December 5, 2024

**Re: Sombra del Oeste Subdivision at 8735 Gibson Blvd. SW
Erosion and Sediment Control Plan
Engineer's Stamp Date 11/18/24 (M09E032)**

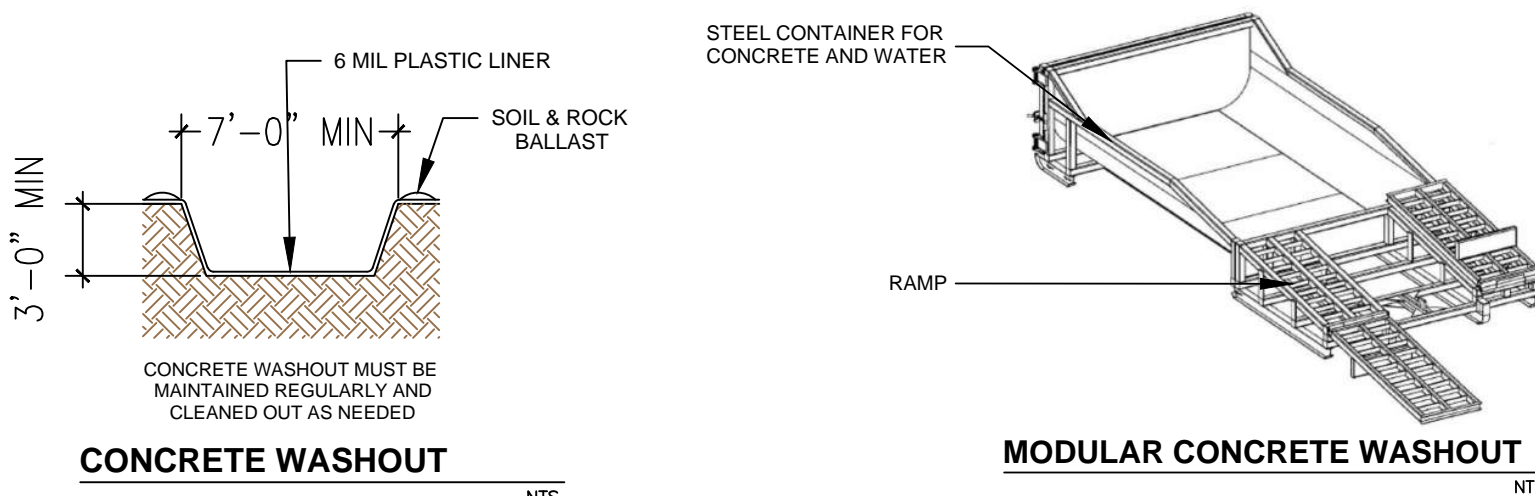
5. The street longitudinal slopes must be shown on the ESC Plan (also typically required on the G&D Plan). Silt-fence or check dams must be located between each lot in the Cutback Curb Swale where street slopes exceed 2%. The southeast construction exit on the low side of the development should be deleted to prevent stormwater from exiting through the opening in the perimeter BMPs.

SHEET:
10

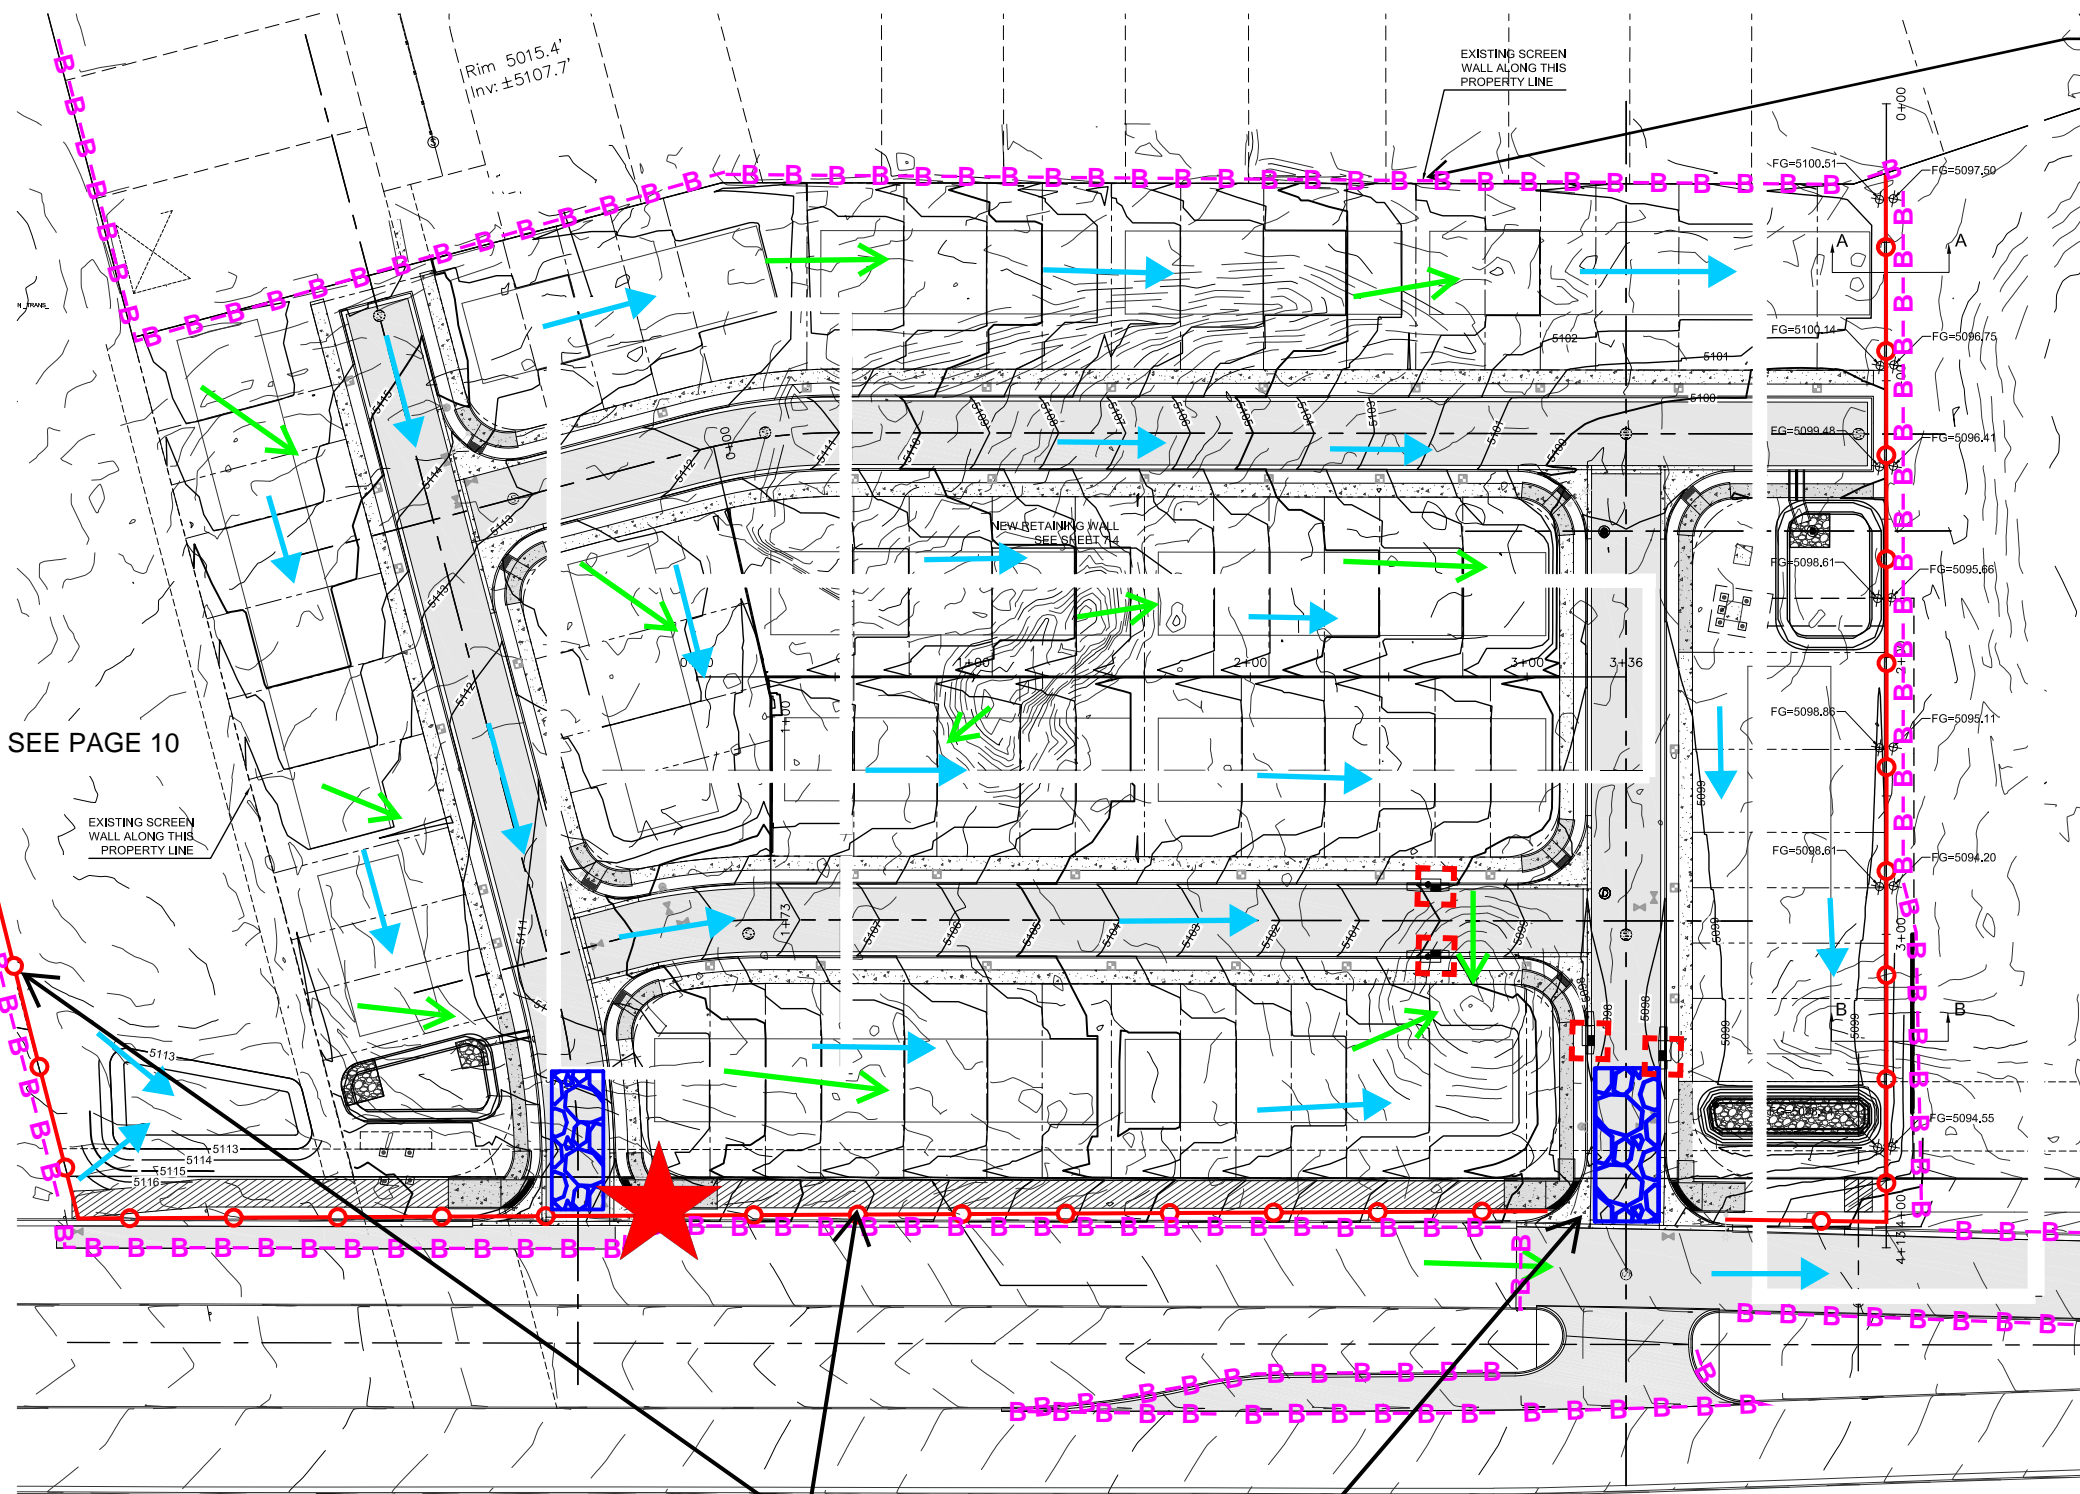
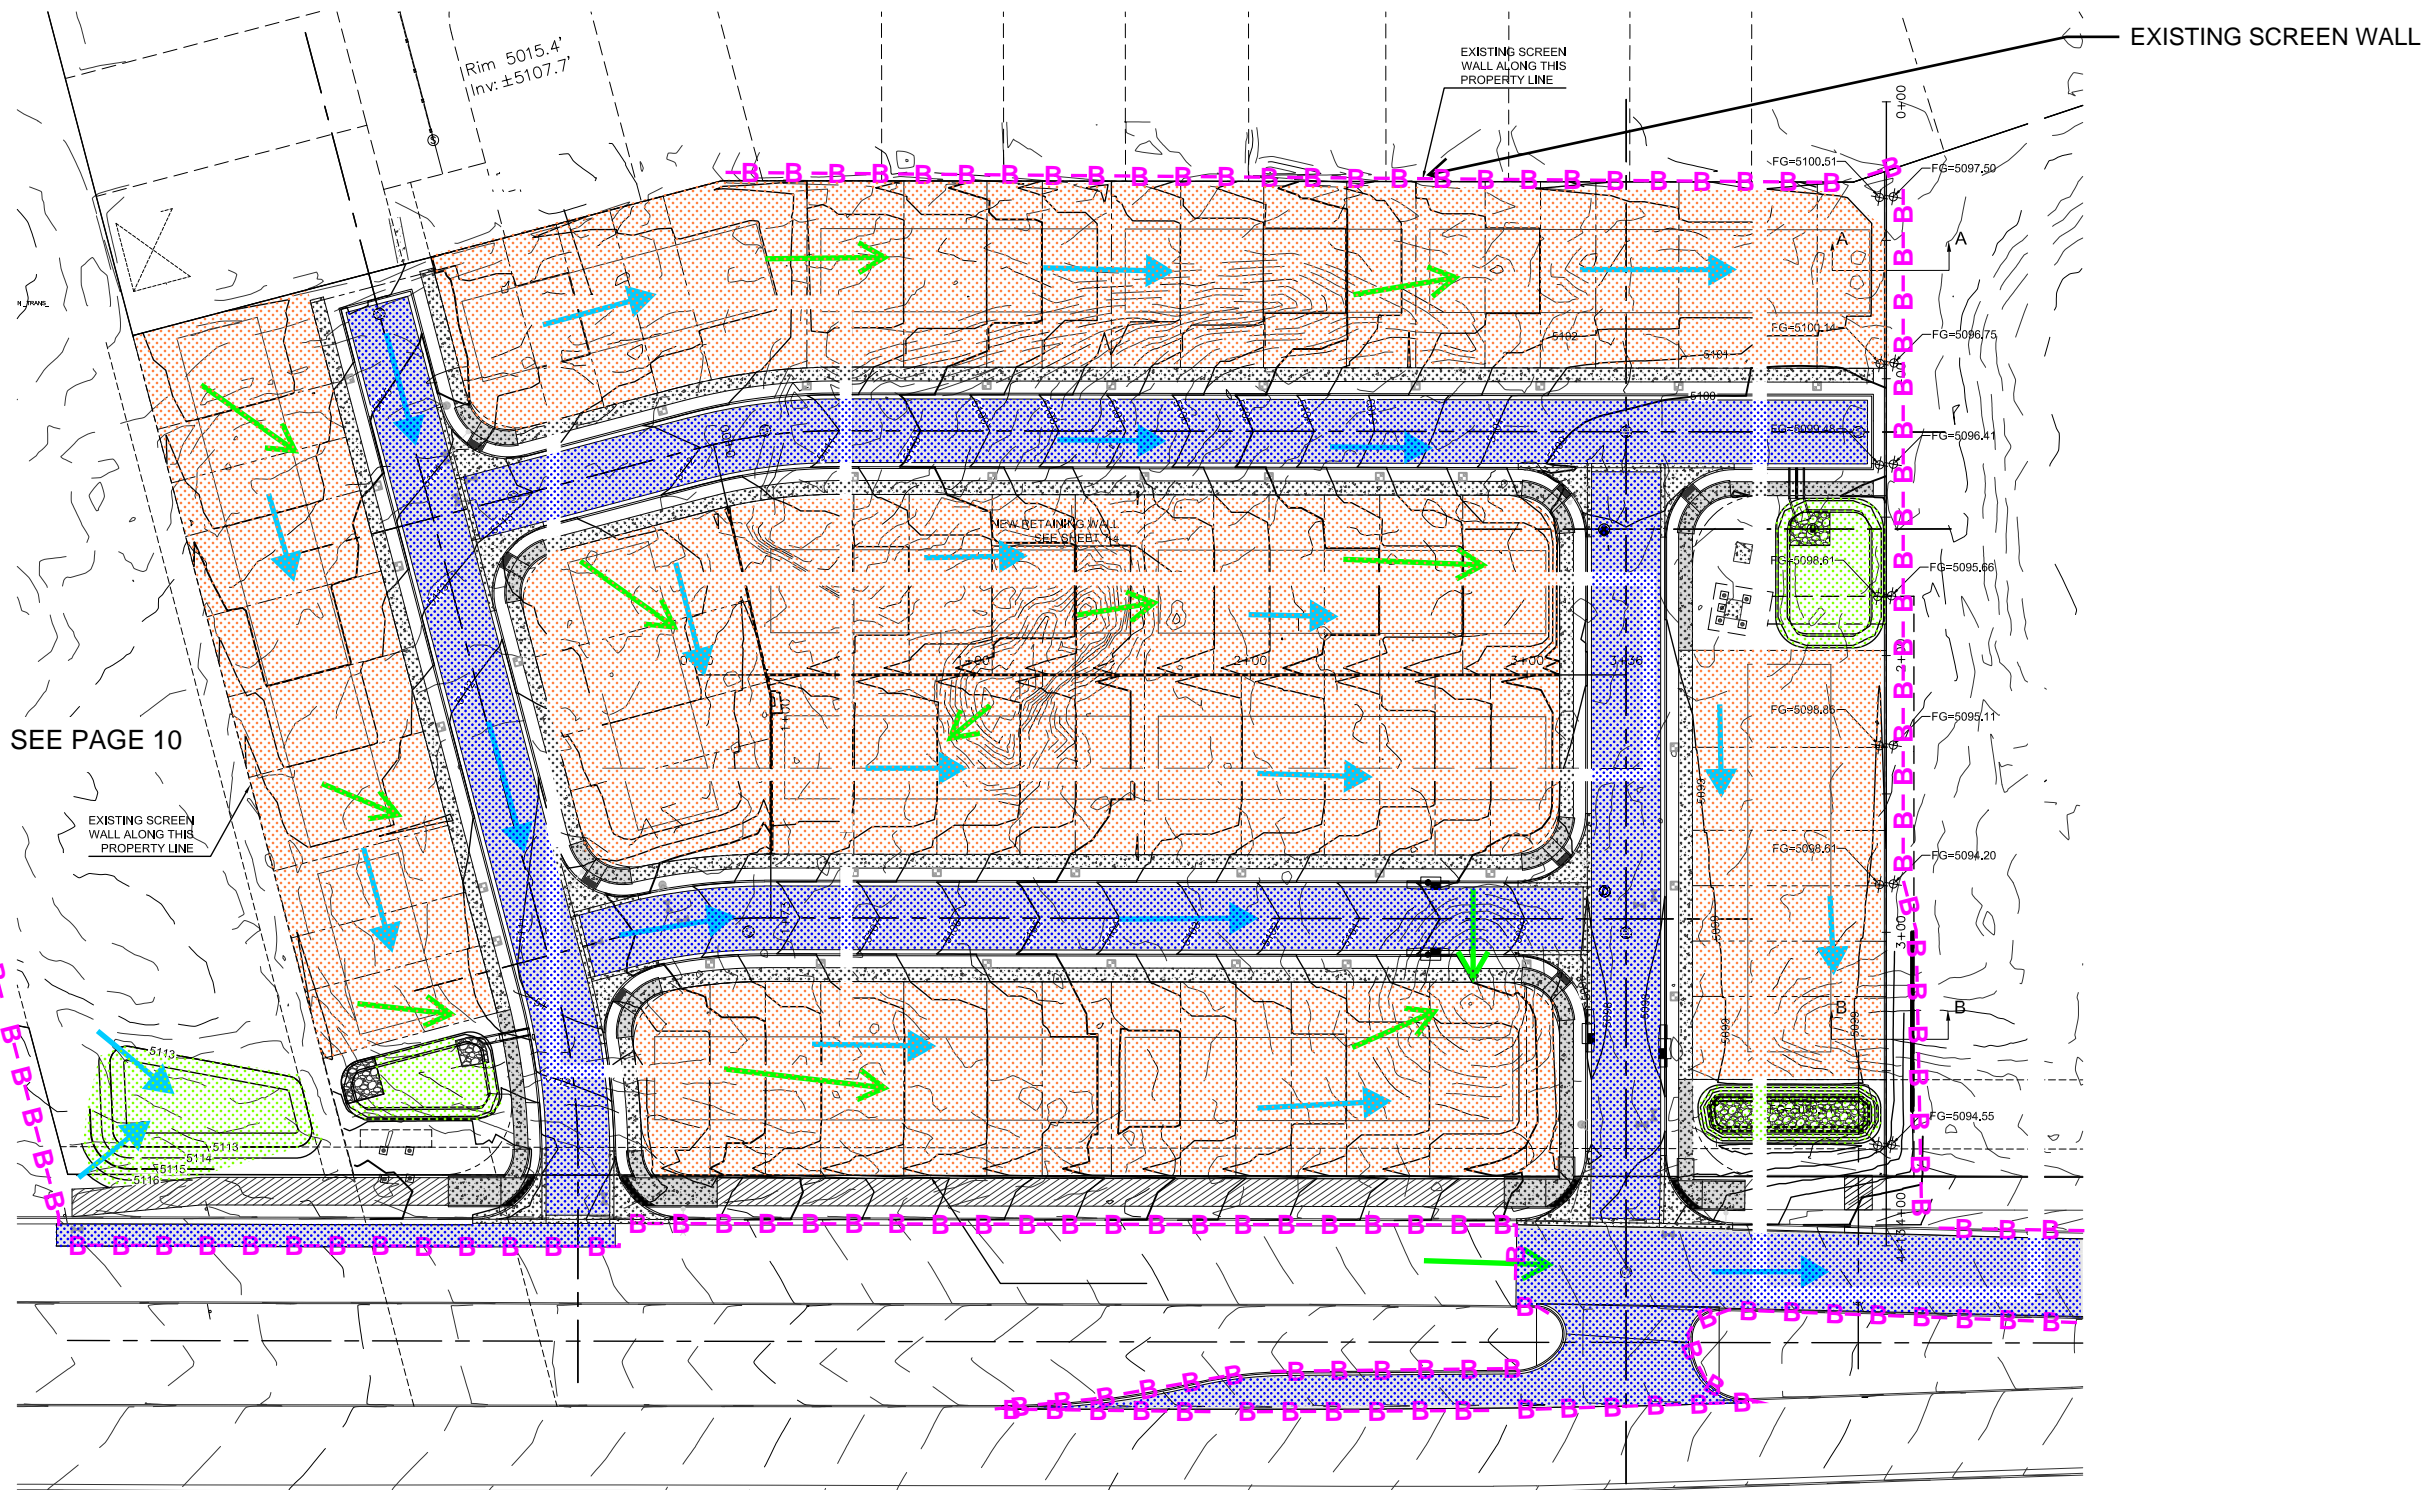
1. Since Ponds B & C don't meet either post-construction or during-construction requirements for BMPs, either:
 - a. redesigned Ponds B & C to retain the SWQV on the Work Order Plans and on the G&D Plan as required by DPM Article 6-12 as required by Hydrology or

- b. Pay fee-in-lieu per DPM Article 6-12 as required by Hydrology and add temporary retention ponds and berms to the ESC Plan per CGP 2.2.12. Include design calculation, dimensions, and construction specifications for additional temporary BMP ponds in the ESC Plan.

3. The grades and layout of the streets and lots on the ESC Plan must agree with the approved G&D Plan attached.
4. The location of ponds and berms must be specified on the ESC Plan for Phase 1, and the location of Cutback Curbs and Silt Fence must be specified for Phase 2, along with a description of the two phases and the timing of the transition from one phase to the other. The Cutback Curbs only apply where the sidewalk construction is deferred to Building Permits. The location of sidewalks to be constructed with the Work Order and the deferred sidewalks should be clearly shown on the ESC Plan.
